Application by Elements Green Trent Limited: Great North Road Solar and Biodiversity Park (Application Reference: EN010162)

Submissions at Deadline 2

Appendix 1 of this letter provides an overview of the documents submitted by the Applicant at this Deadline. Table 1 comprises the application documents for which updated versions are being submitted and summarises how and why the document has been updated.

Drawing Title:
**Public Rights of Way and Permissive Routes Plan
Great North Road Solar and Biodiversity Park
SHEET 33 of 39**

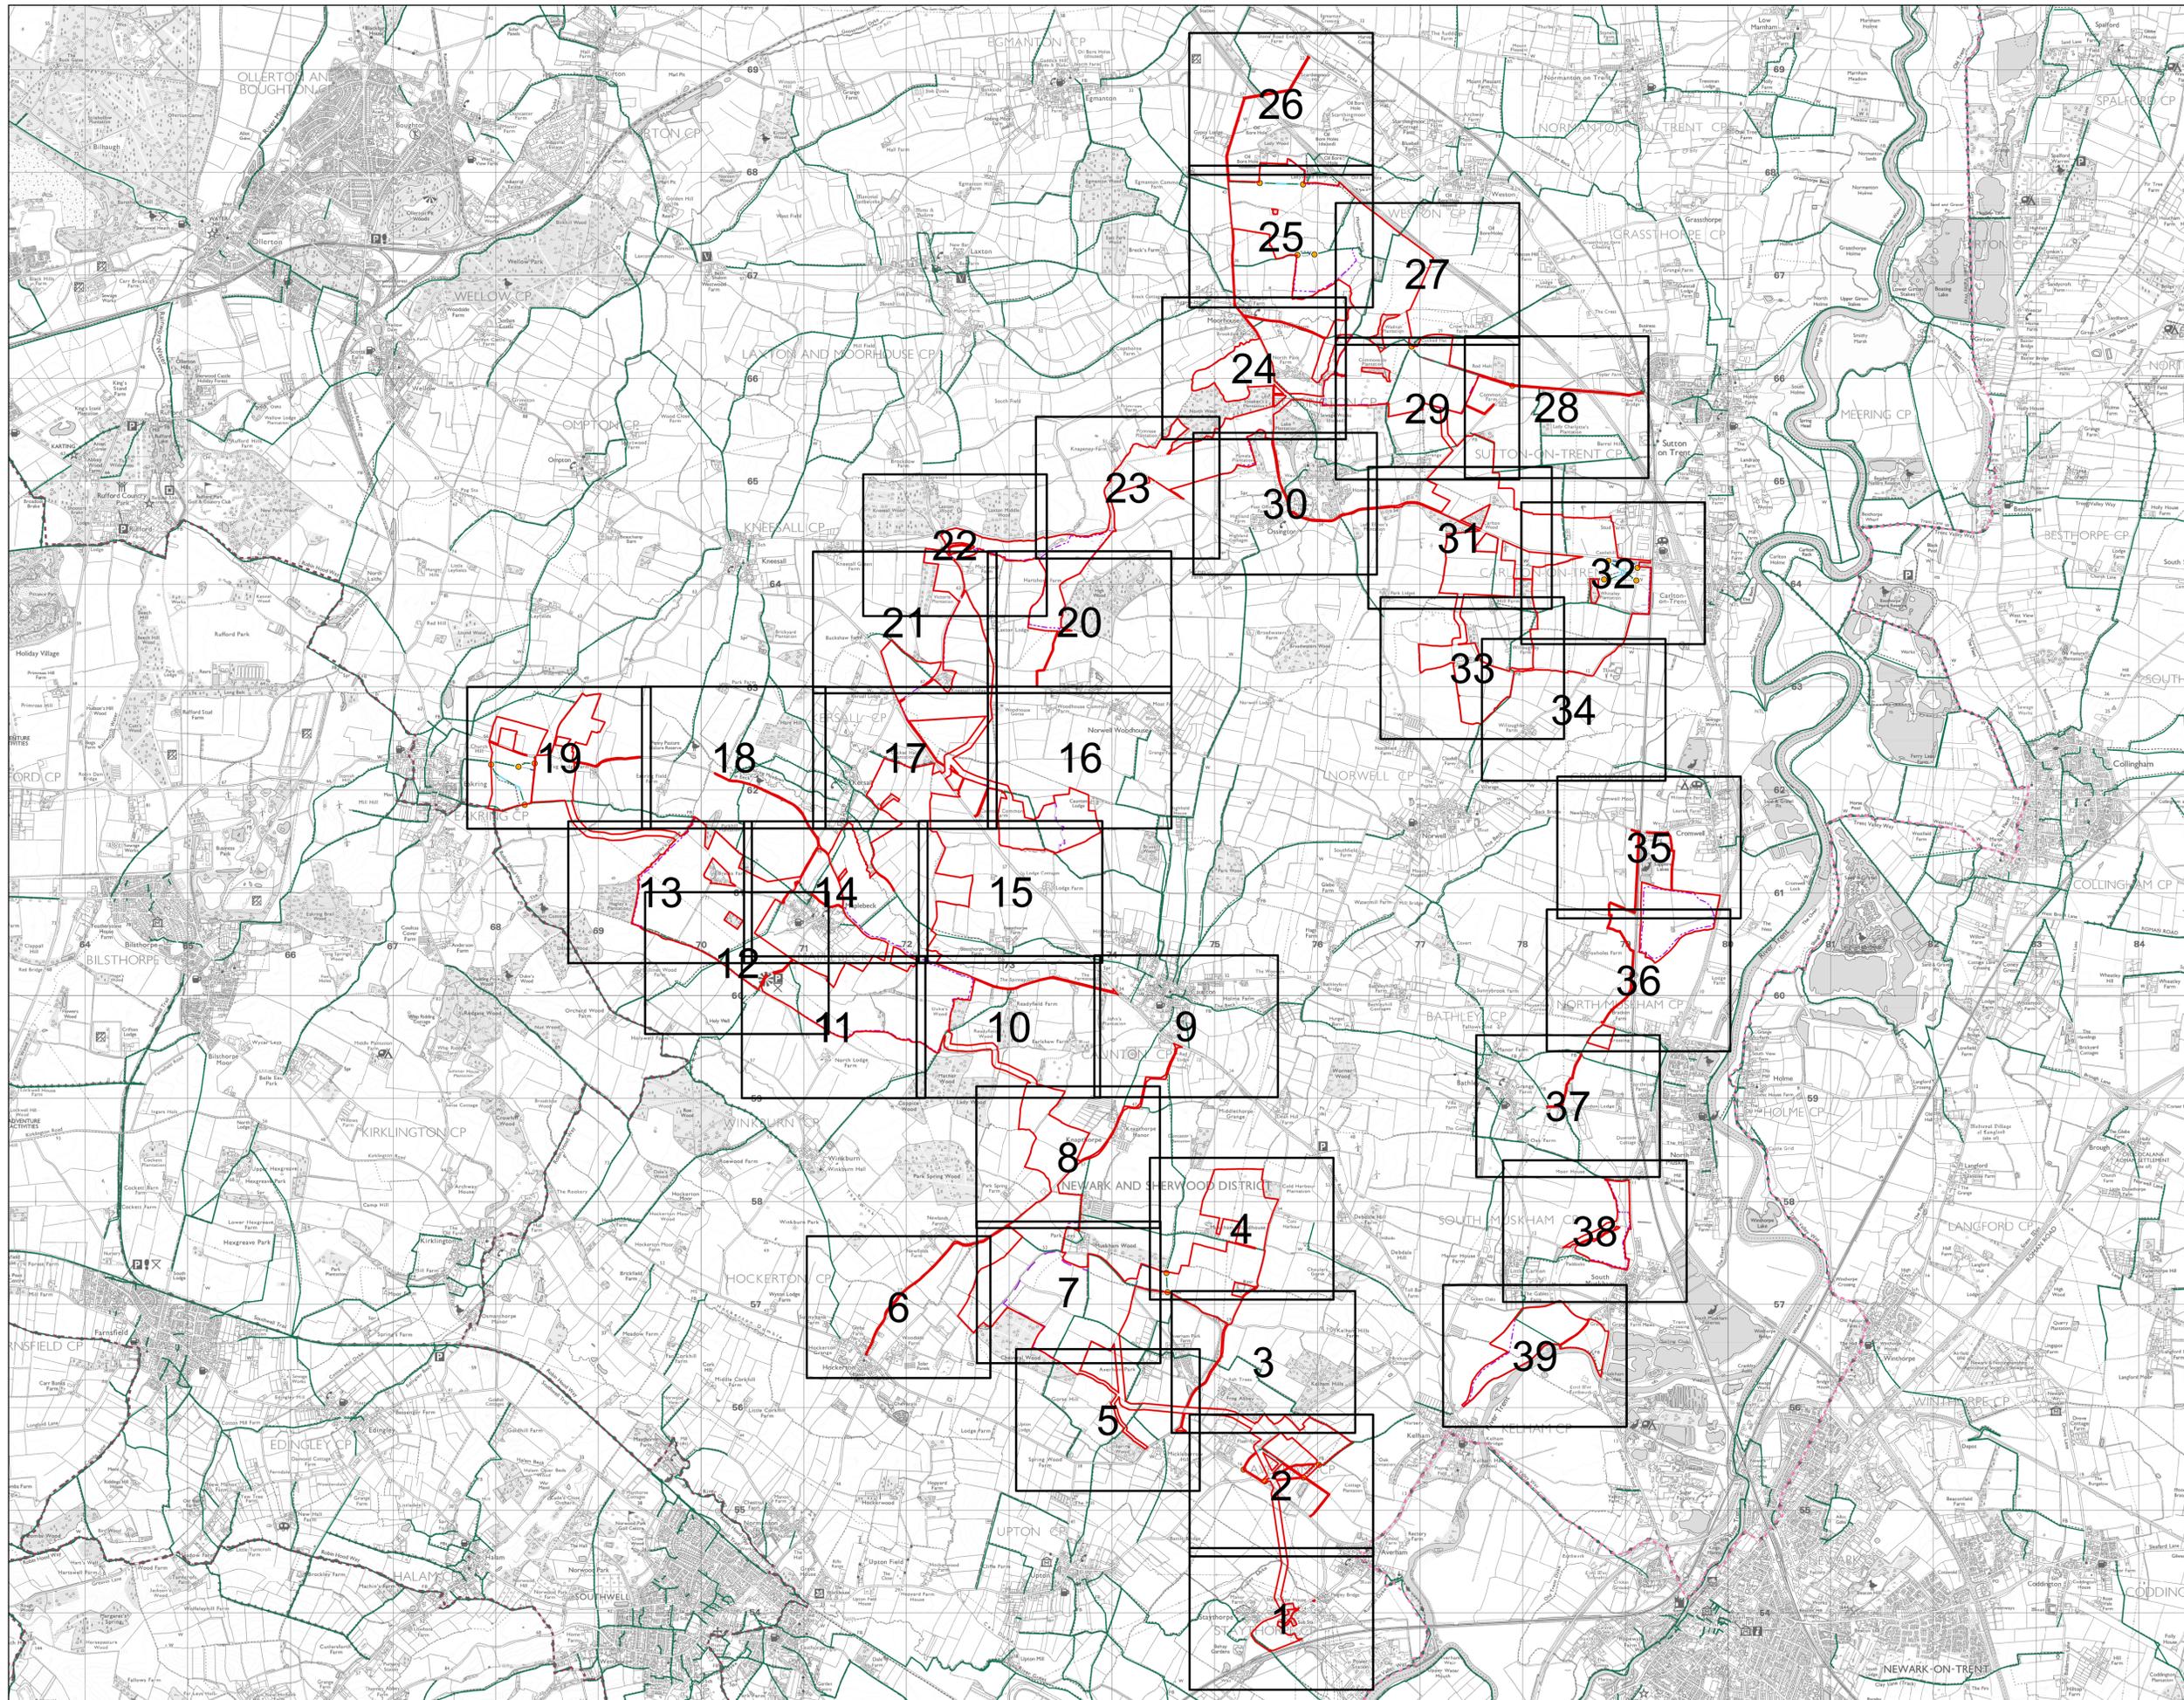
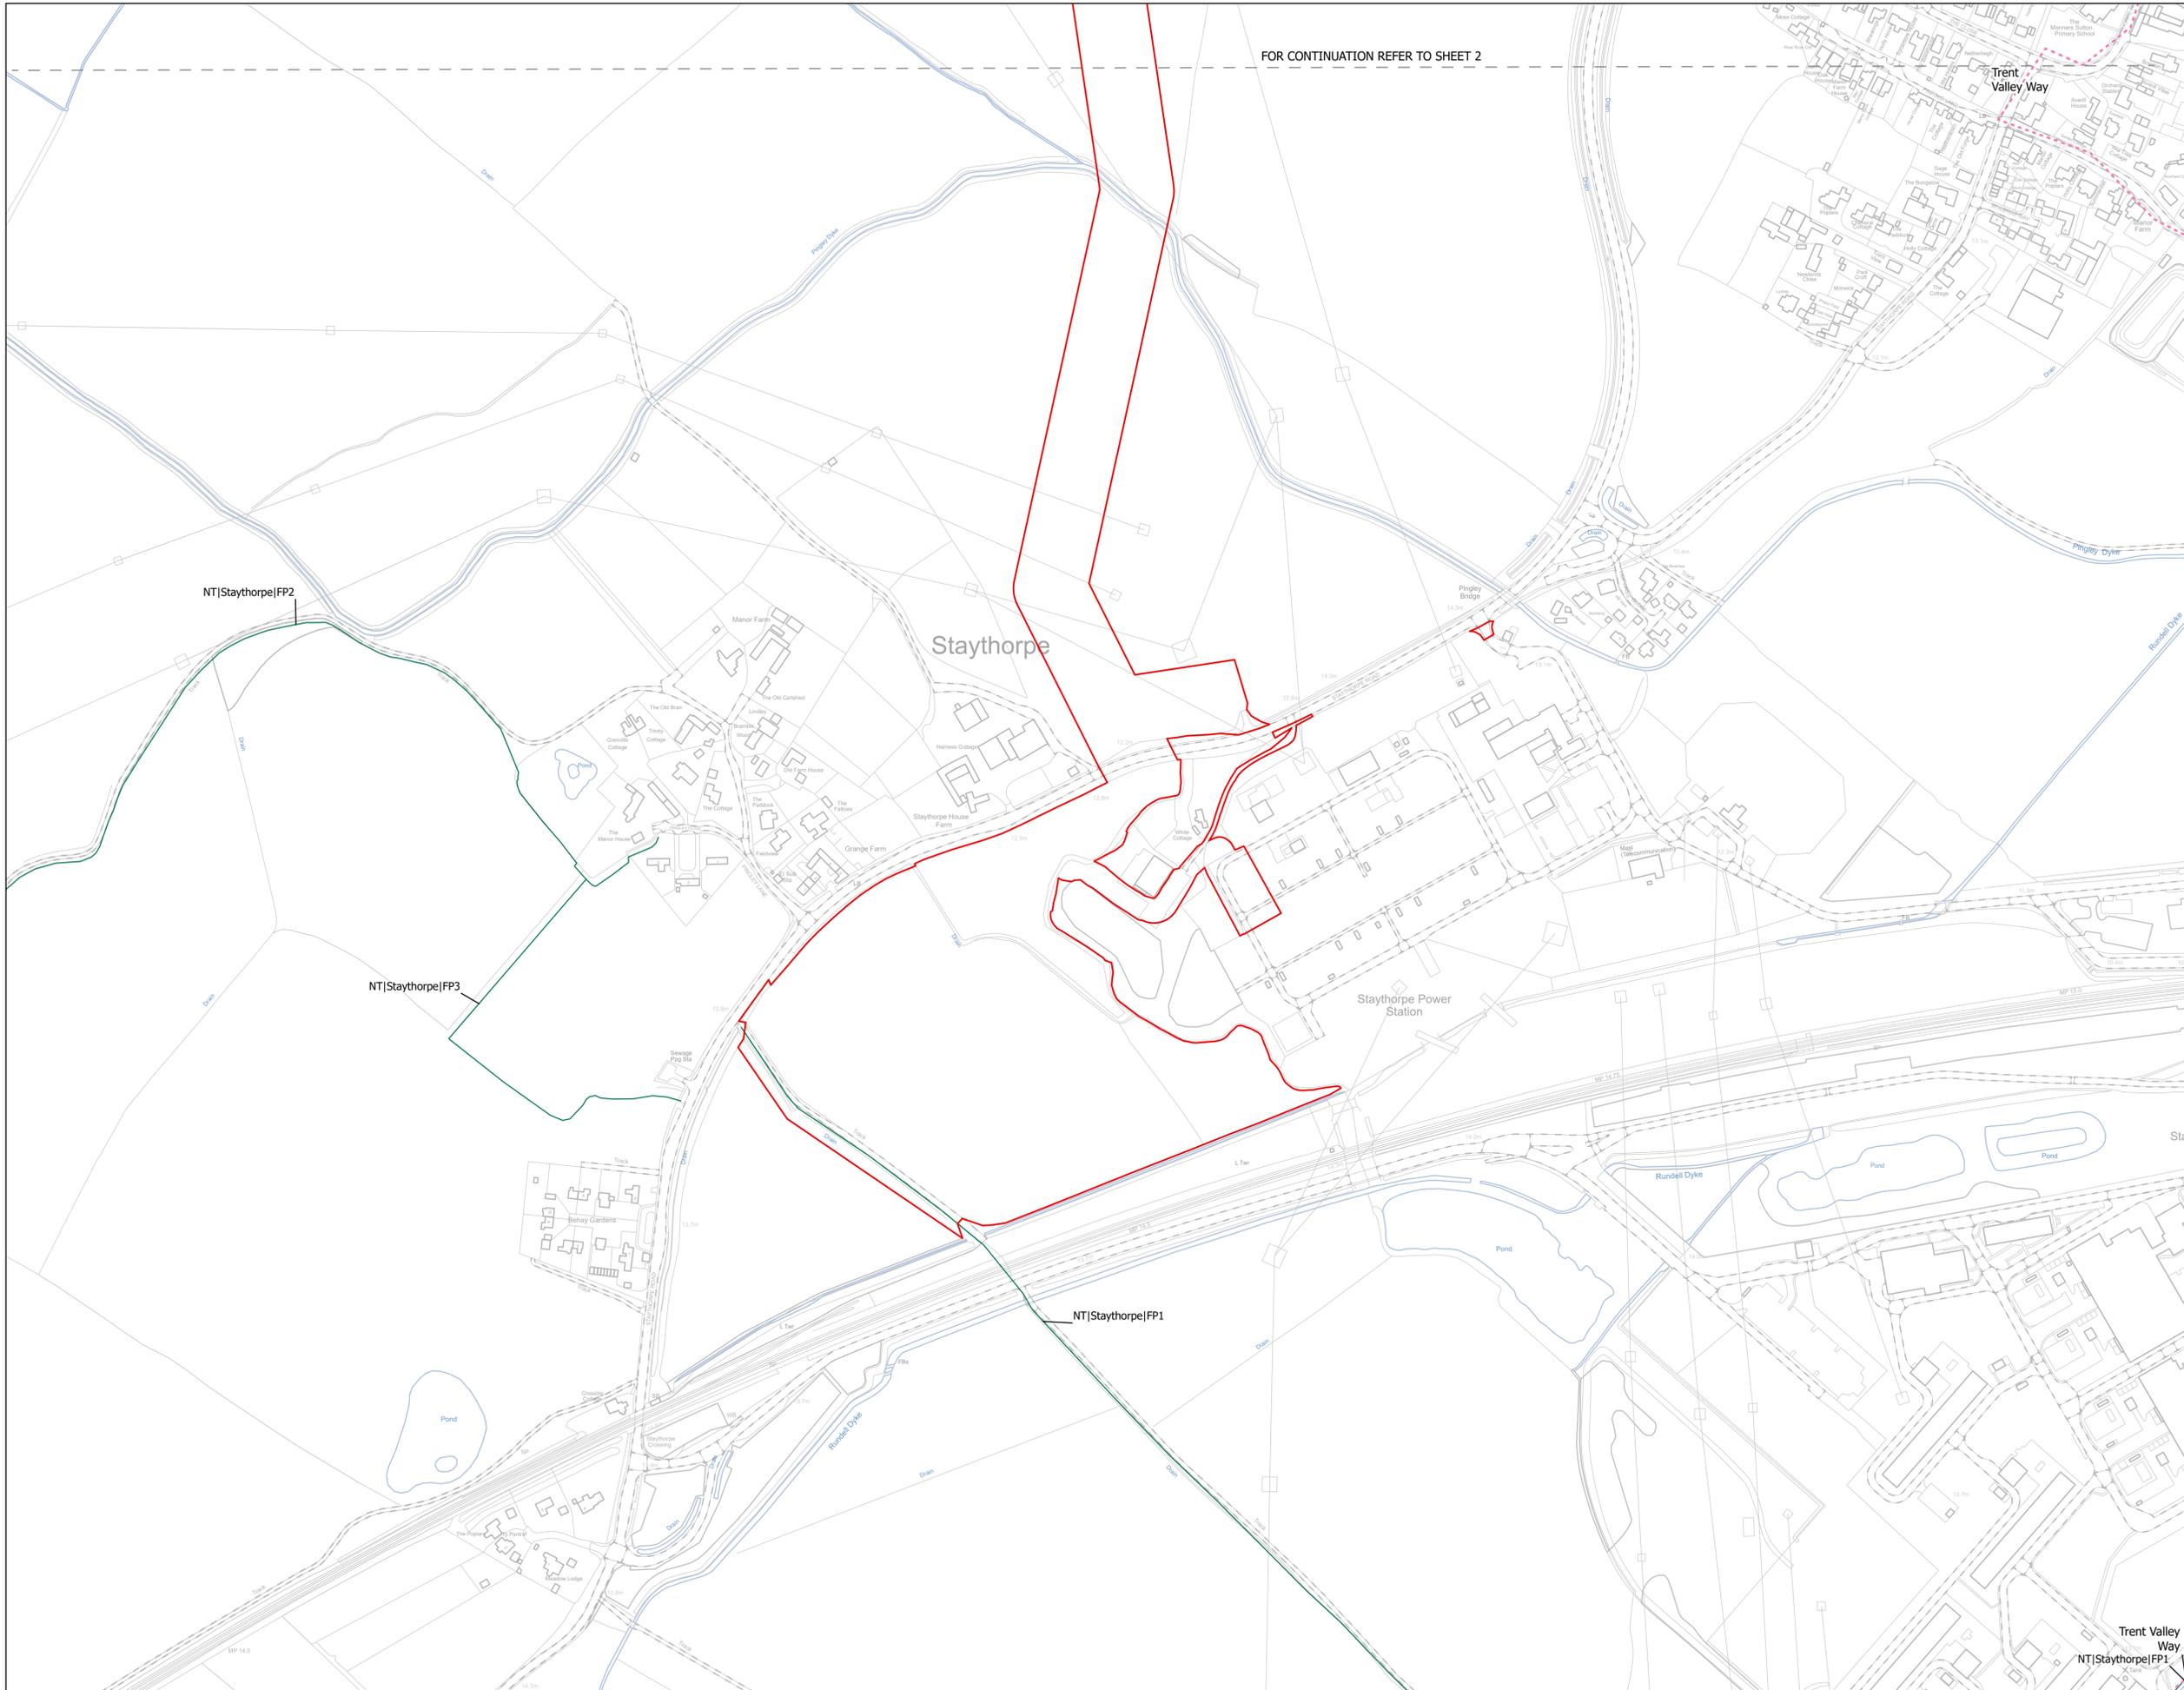
2.4A	2	Public Rights of Way Diversions and Permissive Routes Plan	Updated Figure to remove part of Permissive Bridleway along Bridleway Diversion for Construction and Decommissioning only route
